Online Comment

Application H02-0033-26
Location Land to Rear of 53 West Street Crowland Peterborough PE6 0EE
Proposal Construction of new detached dwelling

Name Greg Watkinson
Address Conservation Officer

Drawing Title:  
Proposed Plans  
Elevations & Site Section

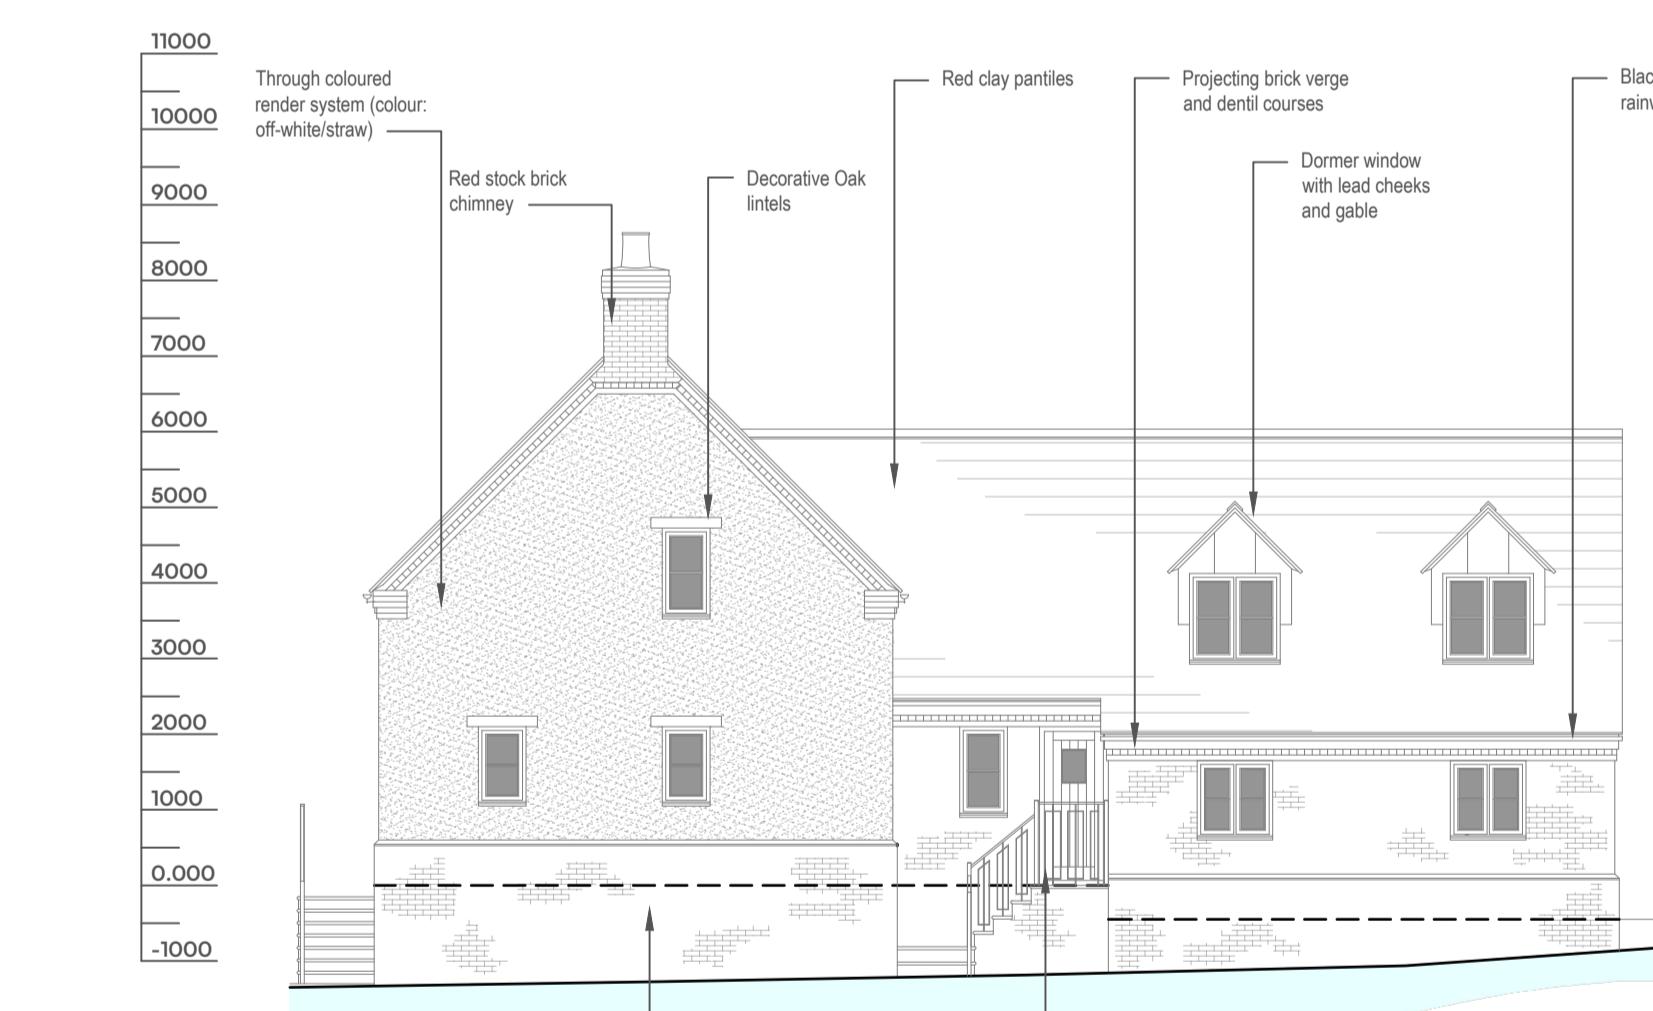
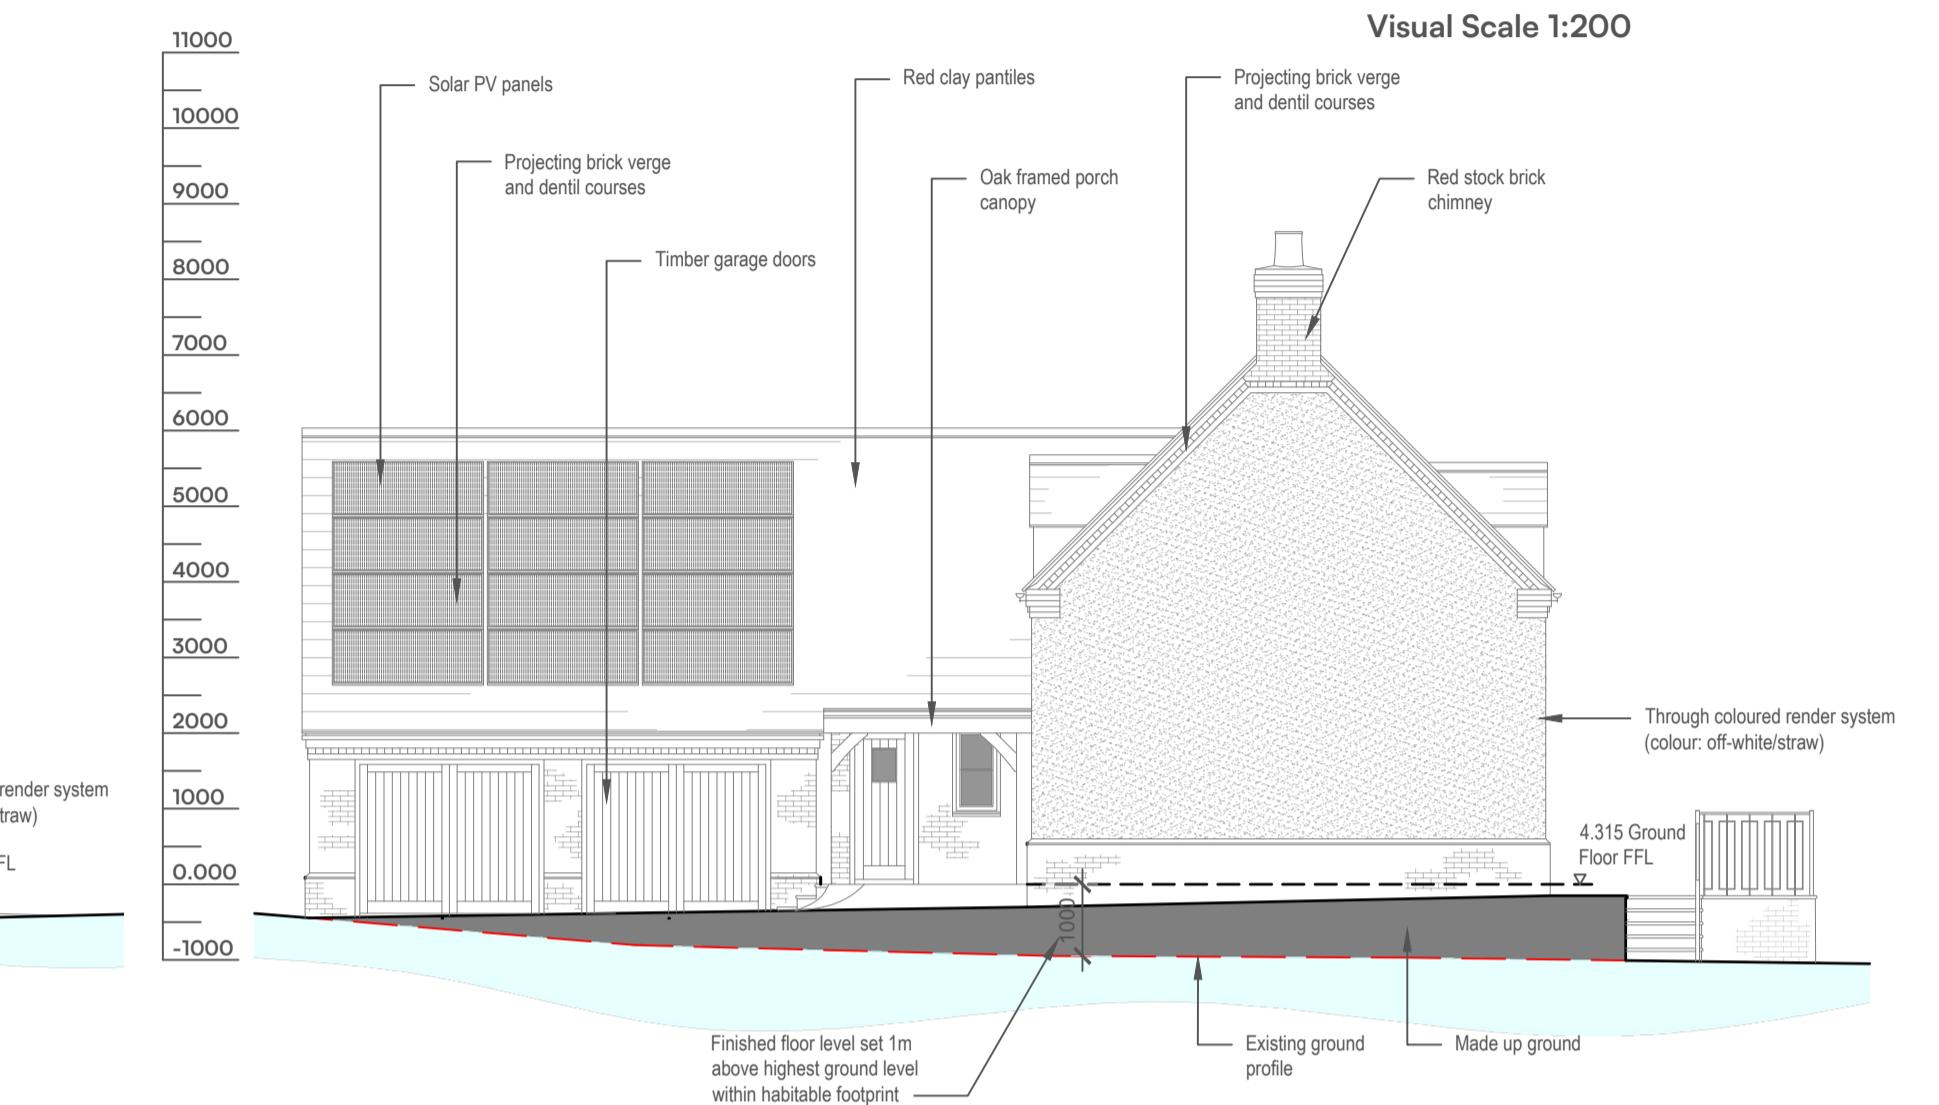
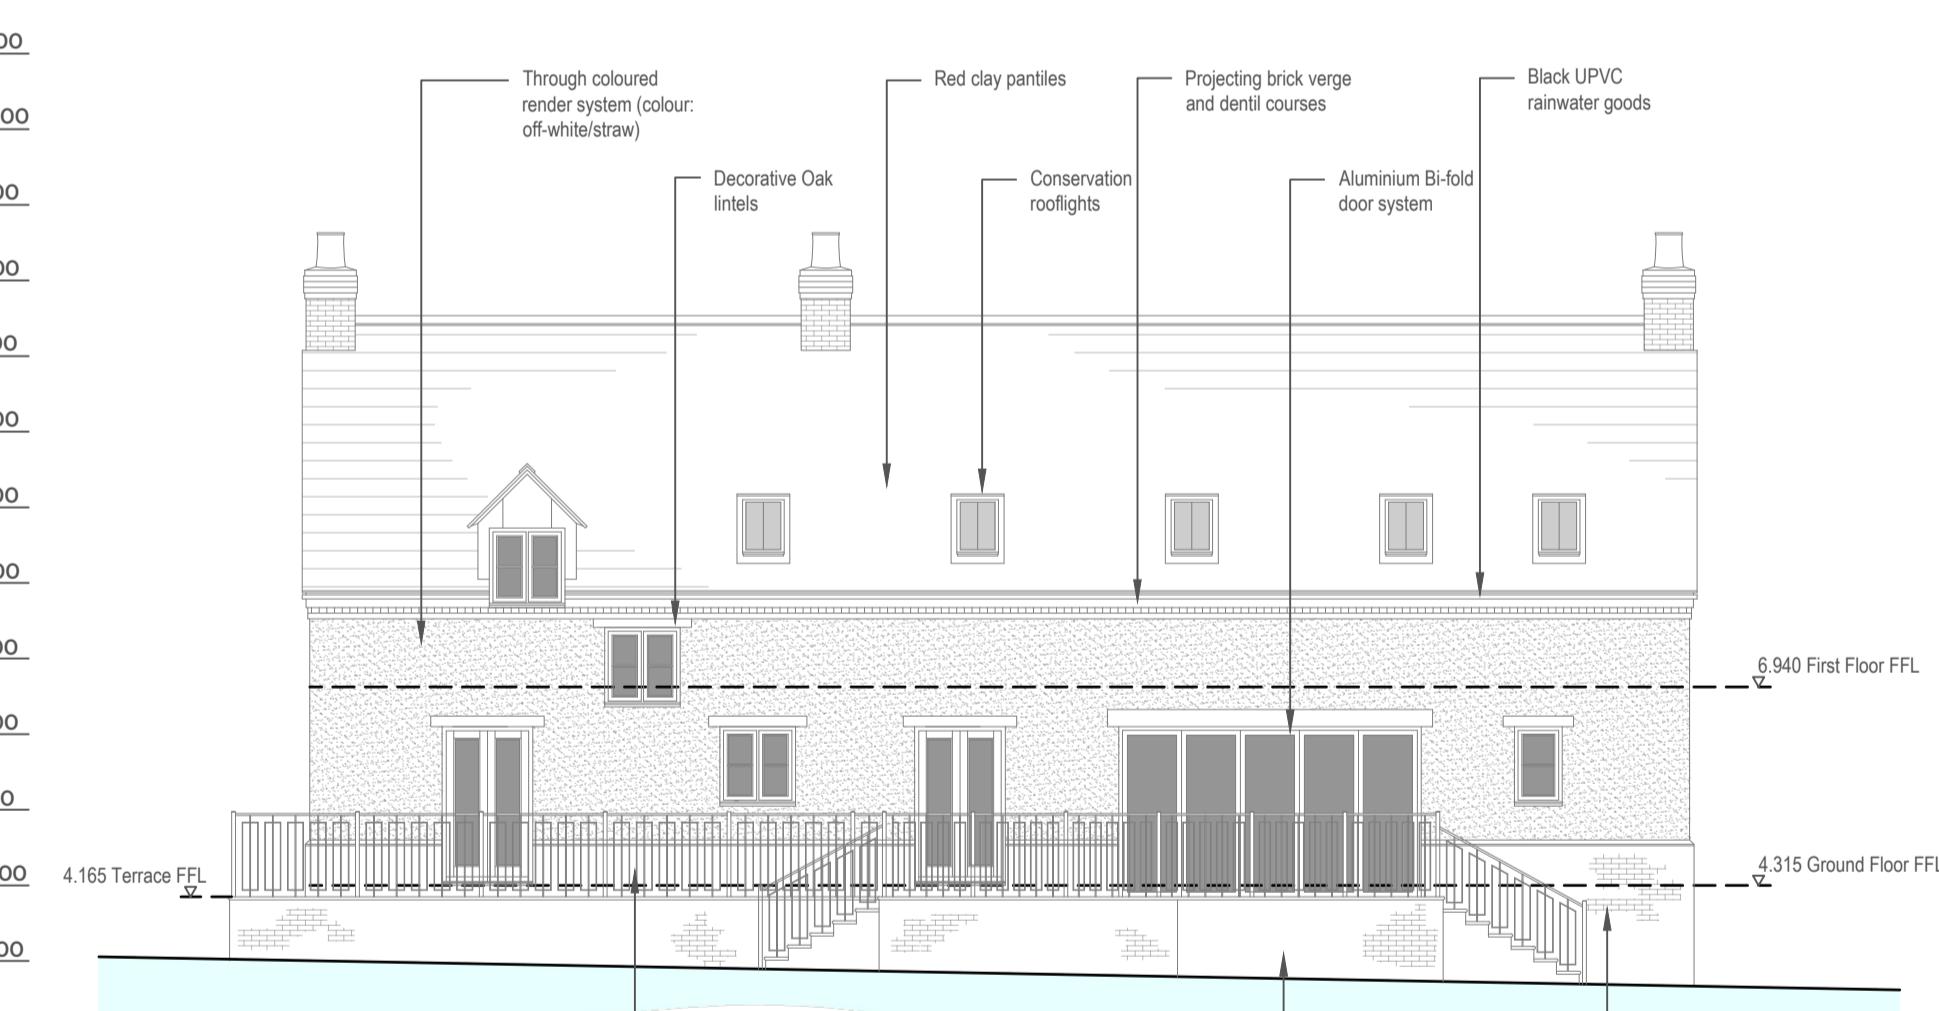
It is noted that the applicant proposes the use of UPVC fenestration. In such a setting, UPVC may well be acceptable, however, this is only on the provision that the proposed units are of the very highest quality, meaning they must not be storm proof with overlapping frames and can feature no visible trickle vents. As such, their details should be a matter of condition if the applicant cannot confirm prior to determination.

Should the application be approved, details of all external materials, as well as domestic accoutrements, in addition to windows and doors should be provided by means of condition.
